415 Cumberland

----- Forwarded message -----
From: **Lauren Swett** <lswett@woodardcurran.com>
Date: Thu, Mar 1, 2018 at 11:54 AM
Subject: 415 Cumberland
To: Jean Fraser <jf@portlandmaine.gov>

I took a look at the submission for 415 Cumberland from yesterday's meeting, to see if there is anything that would require a civil review.

Sheet Title:	<b>SITE PLAN</b>
--------------	------------------

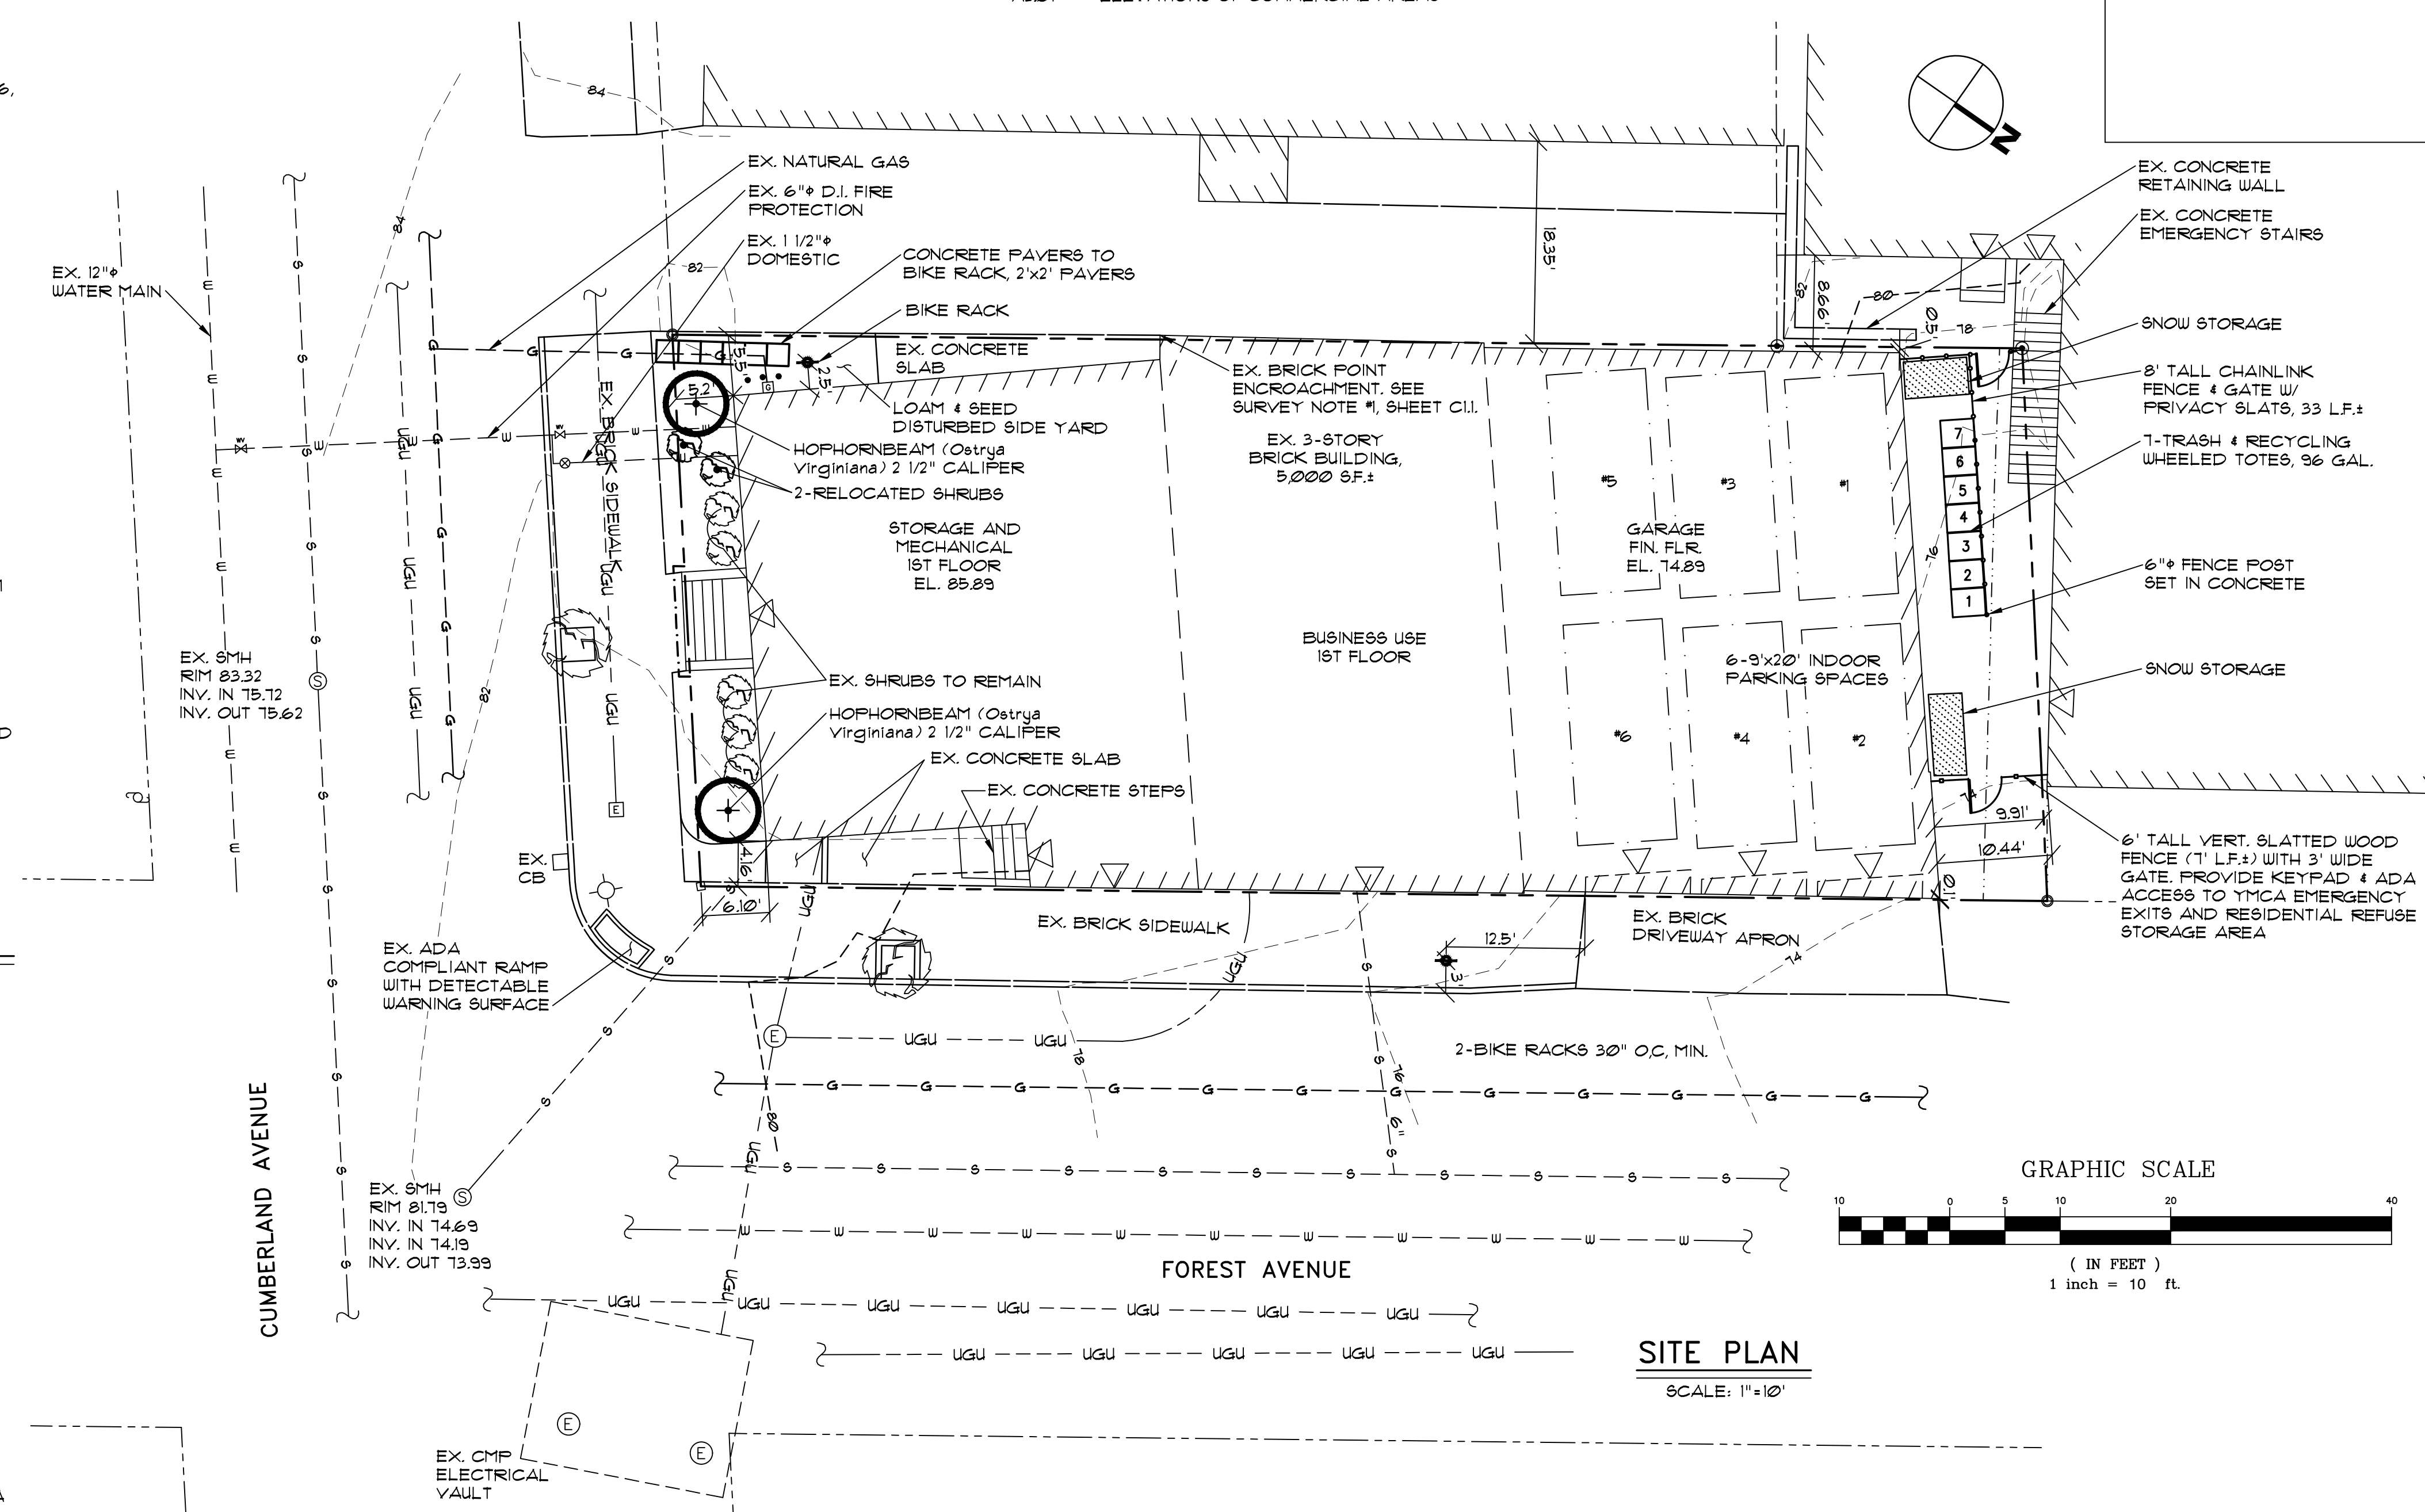
- Street view identifies that there is a tree in the sidewalk on Cumberland Avenue. The plan doesn't show that it exists and/or is being removed.
- The existing ADA ramp at the corner is shown in sort of an odd way – the curb line should be drawn to show the location of the ramp tactile warning strip.
- The light pole shown on the subdivision plat is a traffic light pole with a mast arm. I'm not sure if the plat should identify that.
- The plat shows the ROW line on Cumberland crossing features out of the sidewalk (bottom step and the mulch planter areas). I'm assuming that is the existing condition, but I'm wondering if that needs to be addressed on the plat.
- At the southern corner of the building (plan northwest corner), they are showing a new walkway of pavers. This crosses the sidewalk, and I'm guessing that wouldn't be acceptable to the City.
